**From:** Contact Centre (CRM) <contact@ribblevalley.gov.uk>  
**Sent:** 01 November 2024 11:52  
**To:** Planning  
**Subject:** Planning Application Comments - 3/2024/0465 FS-Case-659083848

**Planning Application Reference No.:** 3/2024/0465

**Address of Development:** Barnacre Road Primary School, Barnacre Road, Longridge

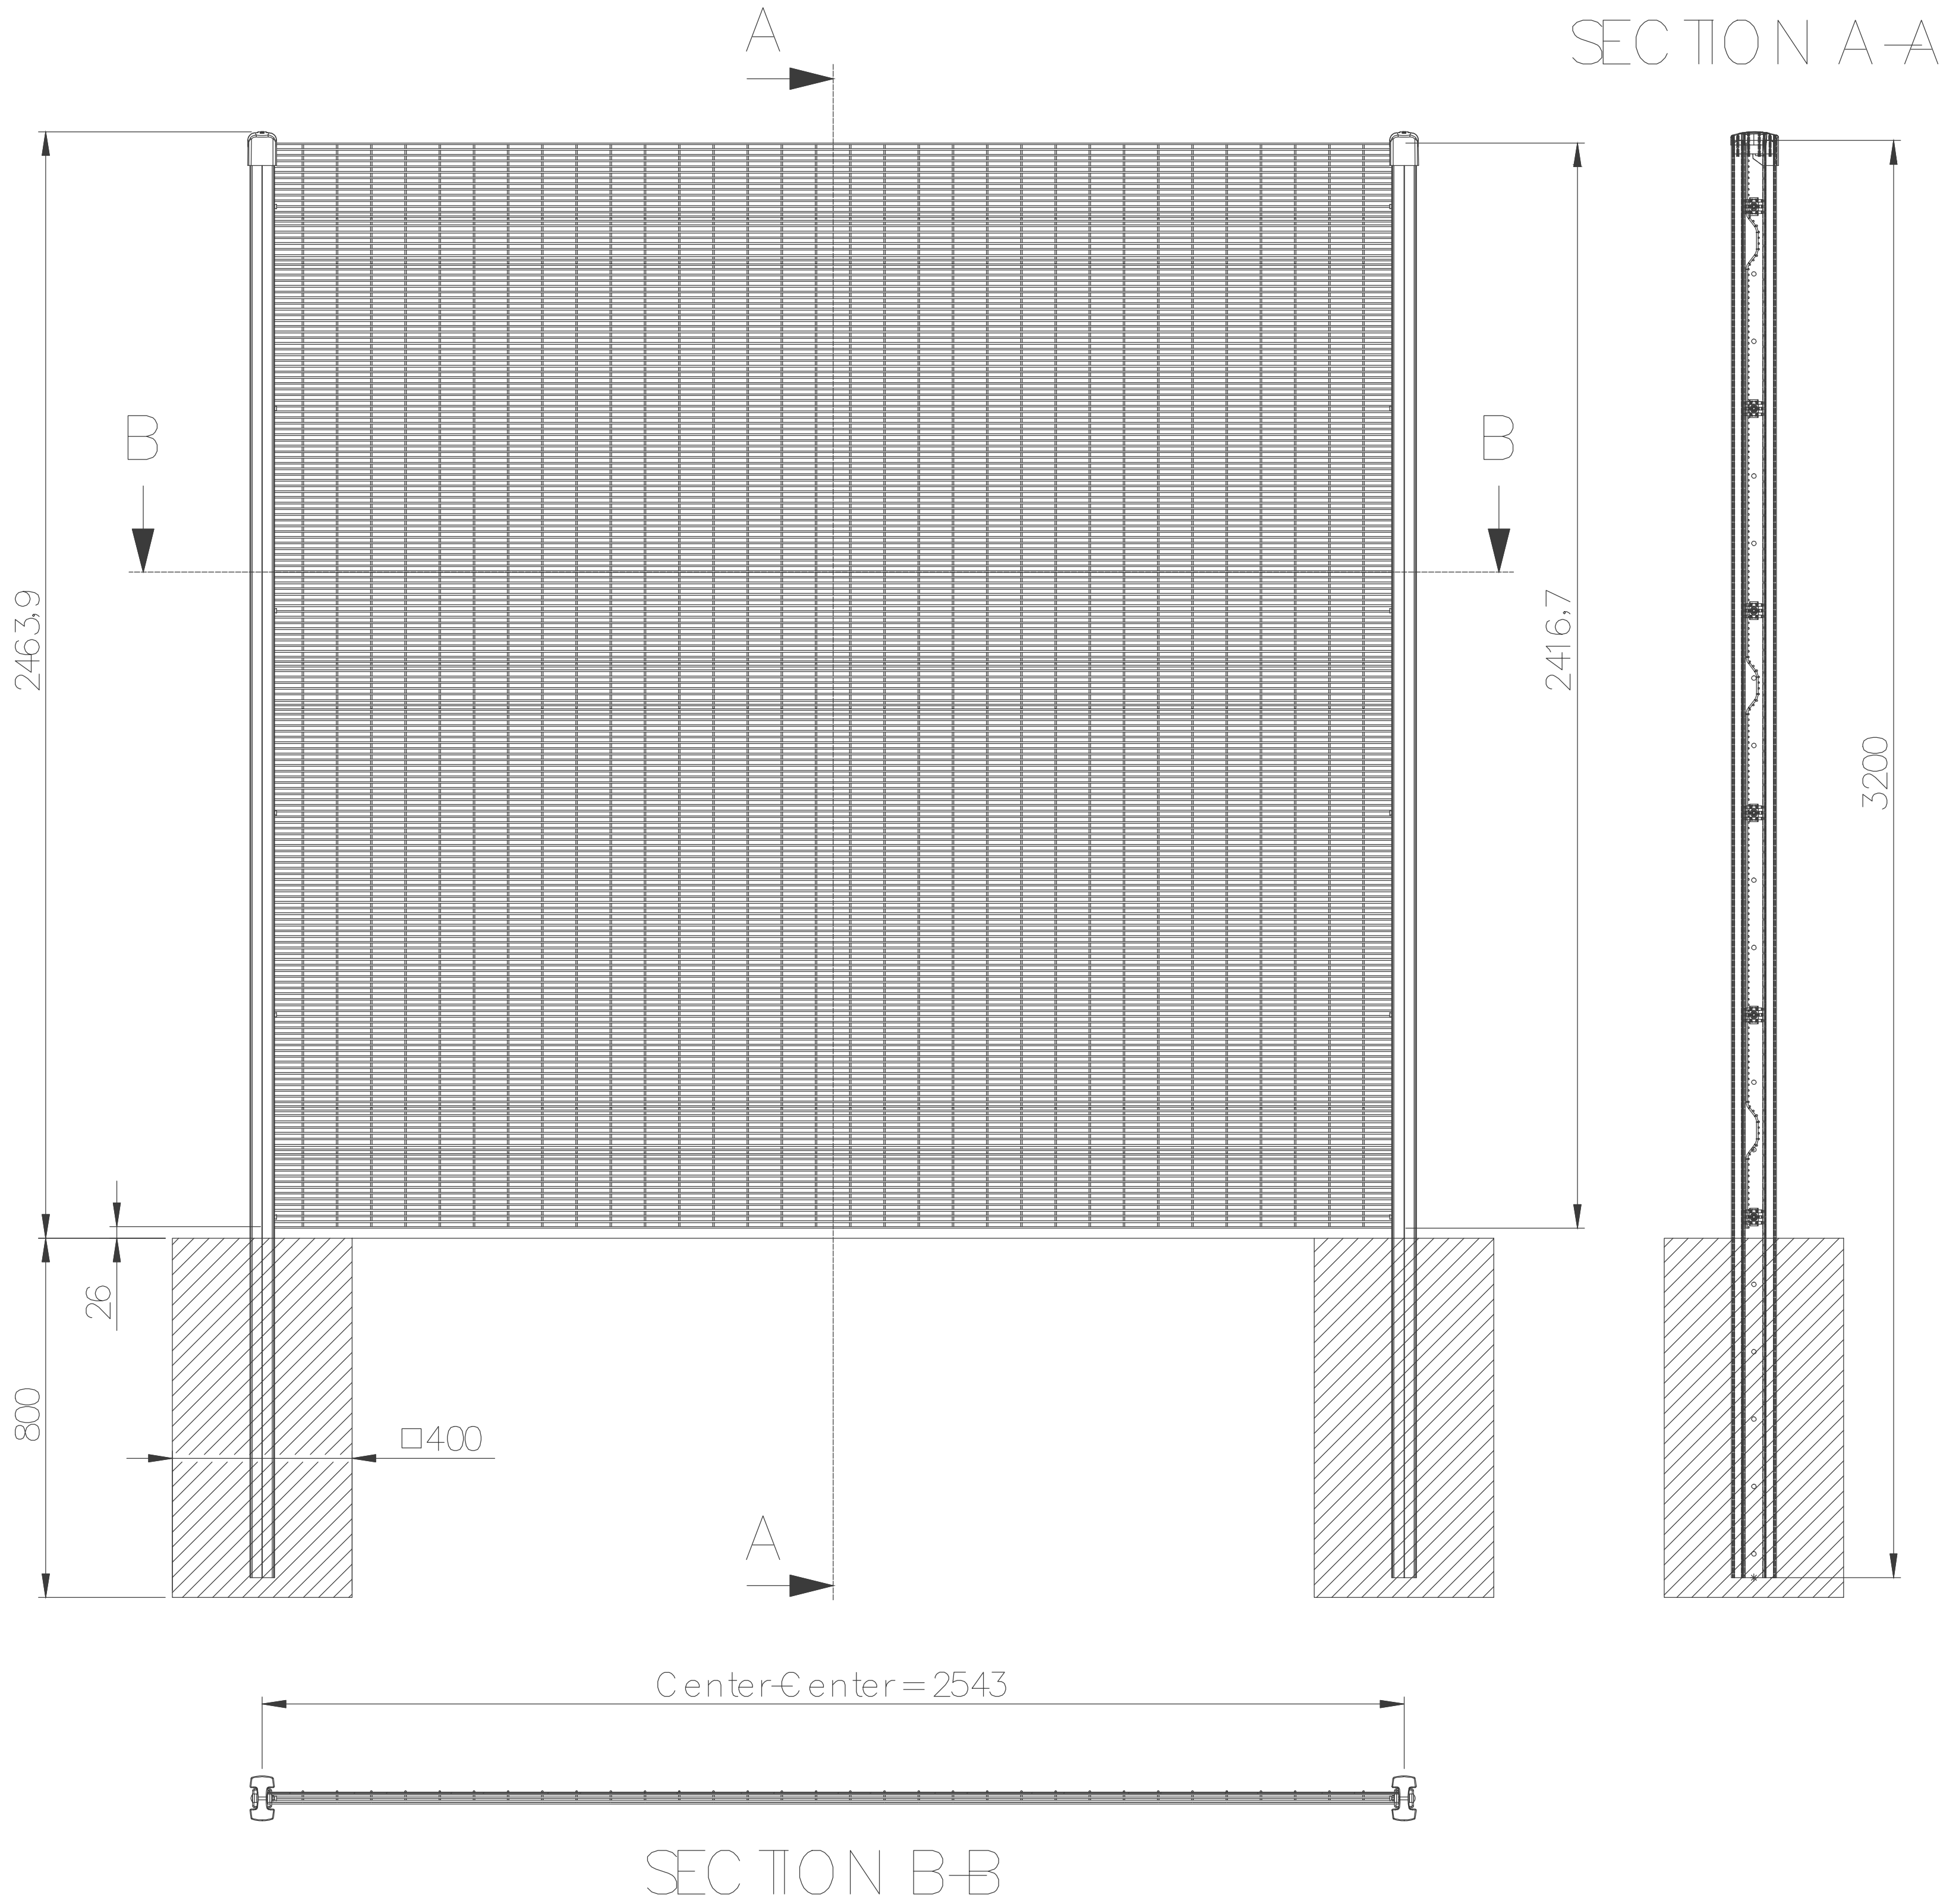
**Comments:** In relation to the fencing application, we note that an 'amended fence elevation' has been provided on 10th October but we cannot see any difference in the height to the previous application height. It is stated that the proposal may fall within the remit of the Party Wall, etc. Act 1966 where if the height exceeds 2 metres, which it does, then any affected Adjoining owners must be notified by way of a Notice. An agreement should then be obtained from the Adjoining Owners in respect of the planned works.

As far as we are aware, no agreement has been made between the Applicants and any of the property owners who have adjoining gardens on the Inglewhite Road side of the proposed fence boundary. Therefore, without agreement by Adjoining Owners , a fence of this height should not be erected.
